WEST SUSSEX COUNTY COUNCIL CONSULTATION

TO:	Arun District Council FAO:Michael Eastham
FROM:	WSCC - Highways Authority
DATE:	18 November 2019
LOCATION:	Bridge Cottage Lidsey Road Bognor Regis PO22 9PH
SUBJECT:	AL/75/19/PL Construction of 8 no. dwellings, alterations to access and associated works - This is a Departure from the Development Plan. More information.
DATE OF SITE VISIT:	n/a
RECOMMENDATION:	Objection
S106 CONTRIBUTION TOTAL:	As previously stated

scale	1:500 @ A3	drawn by	JME	checked by	KC
date	AUGUST 2019	cad file	FIGURE	suitability	rev. P1
drawing number	FIGURE-1.9

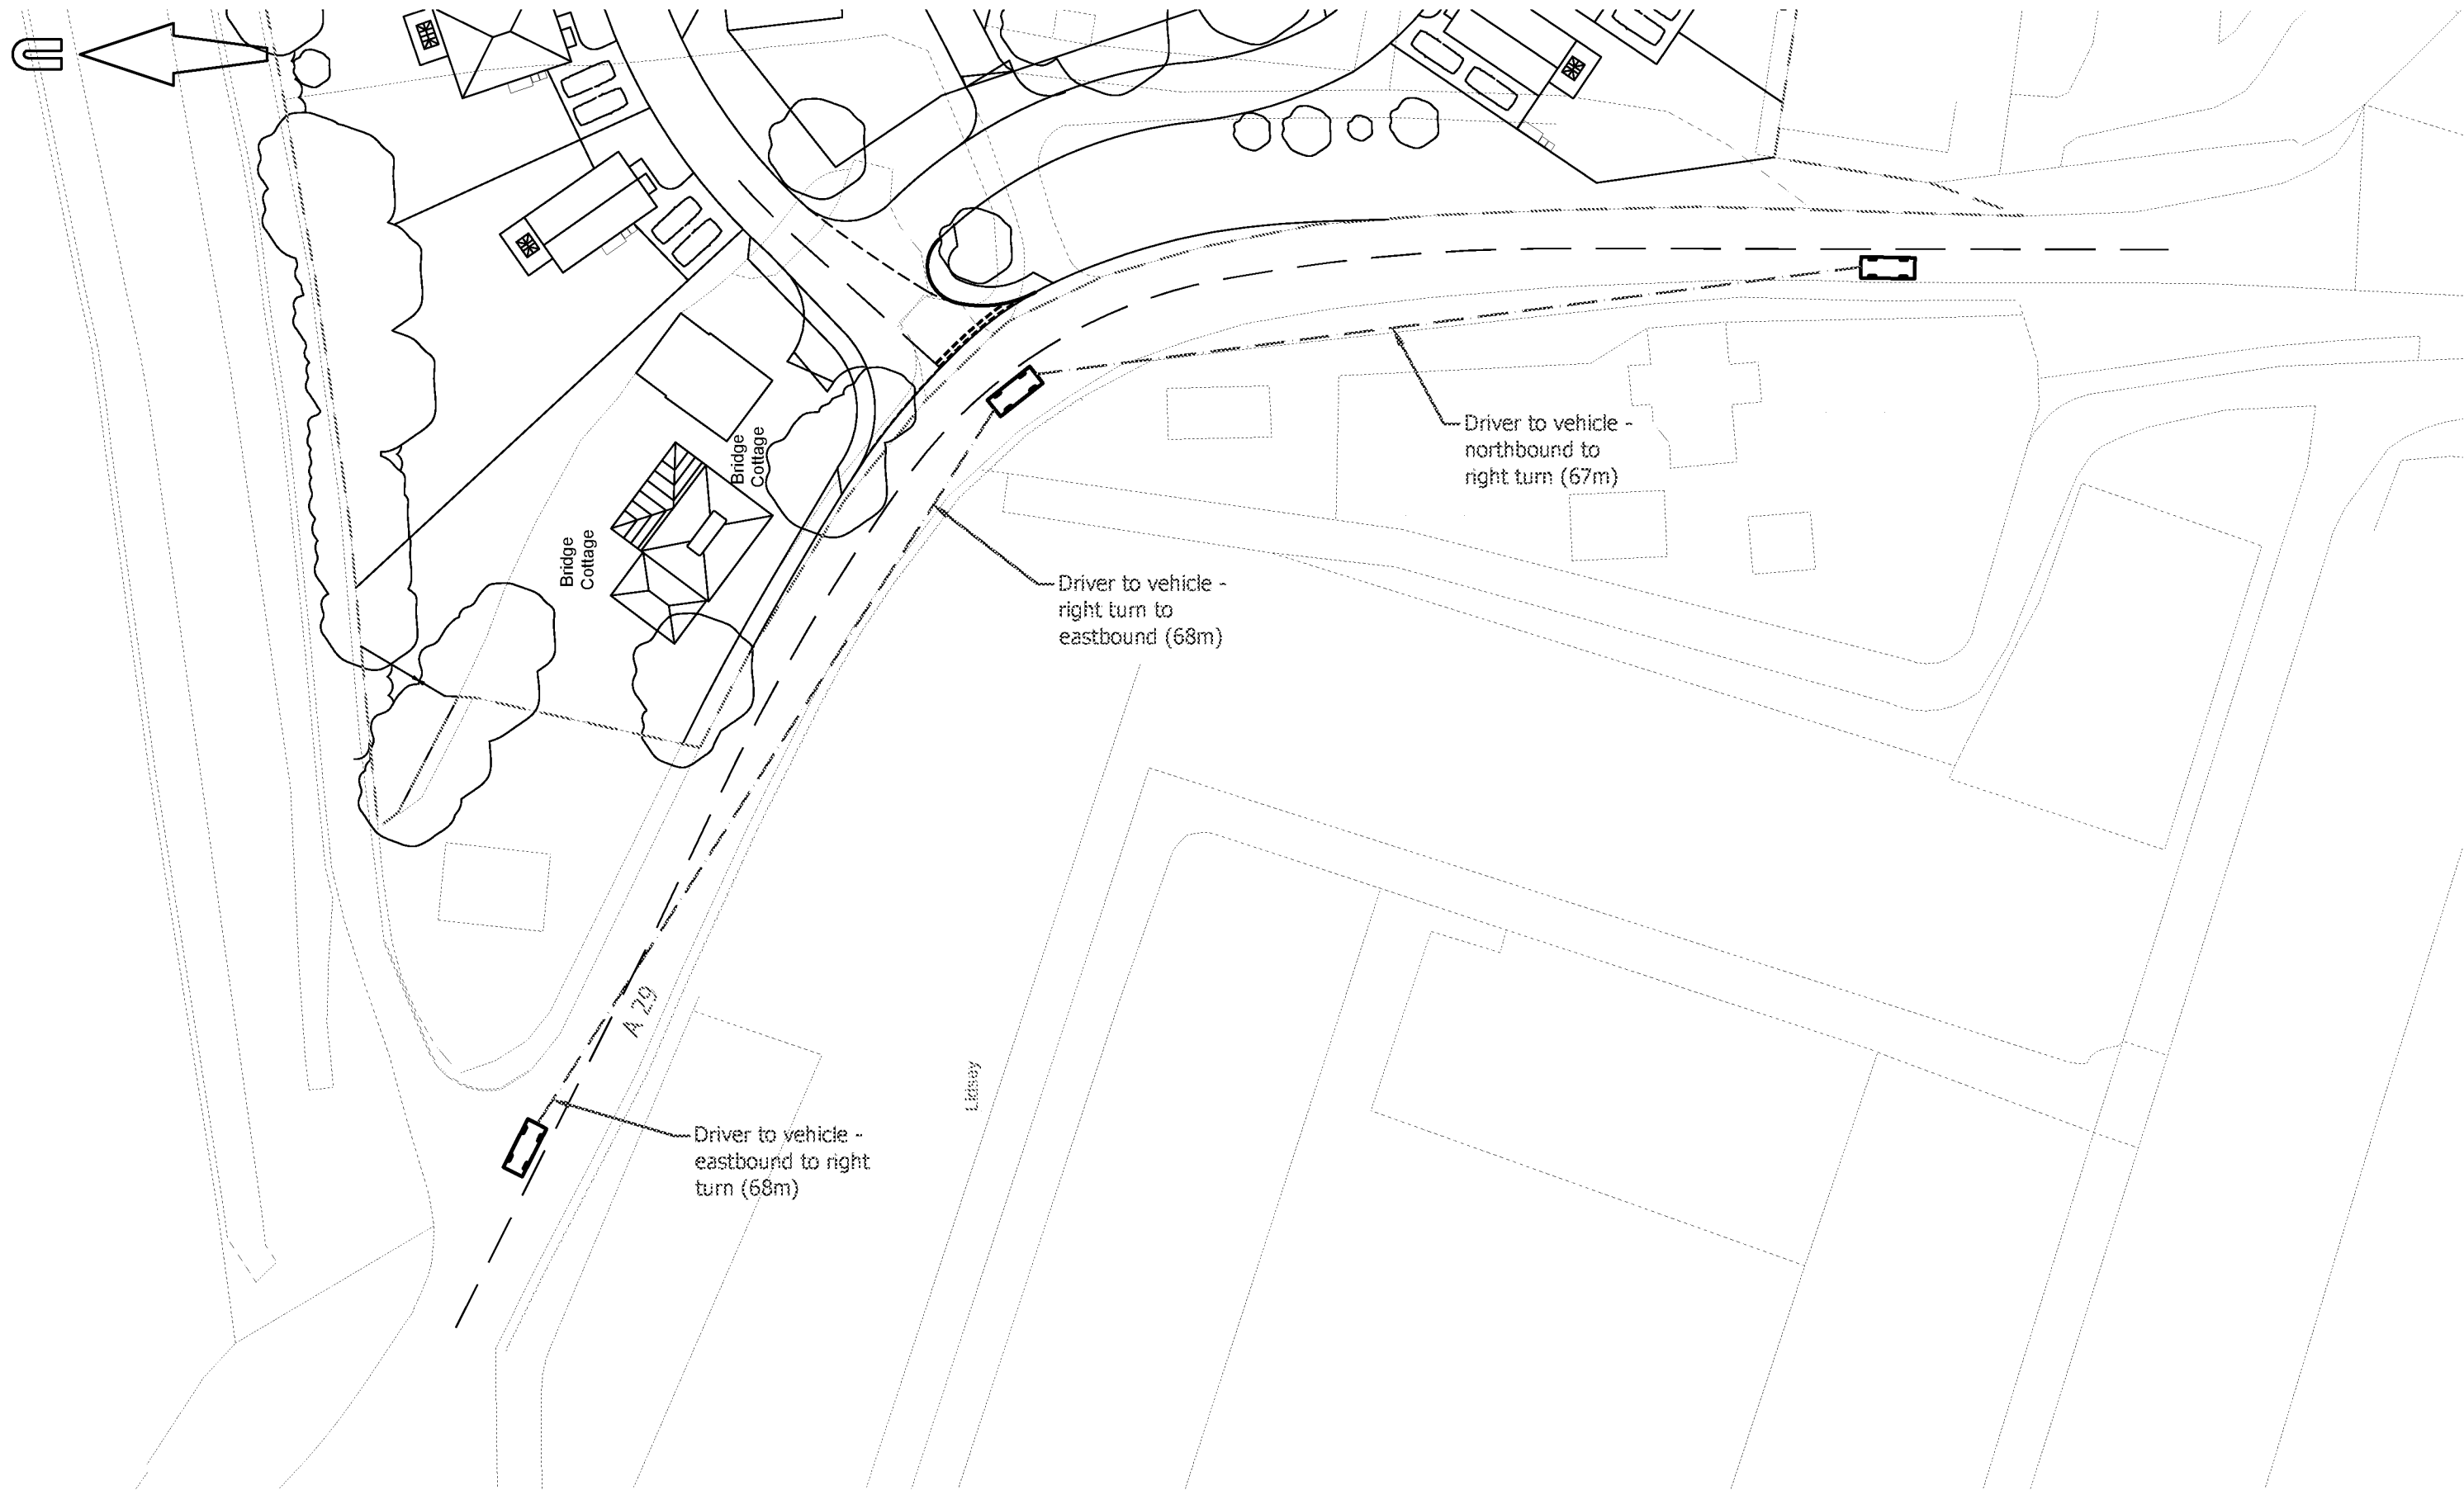
For forward visibility, again no adverse comments are made by WSCC in terms of the distances proposed. The issue with forward visibility is more that these appear to rely on land outside of the public highway. Taking account of the highway boundary information held by WSCC (a copy of which is included with the application), it would still appear that the forward visibility is reliant on land beyond that maintained as highway. The applicant should overlay the highway boundary information on the site access drawing to demonstrate that forward visibility can be achieved.
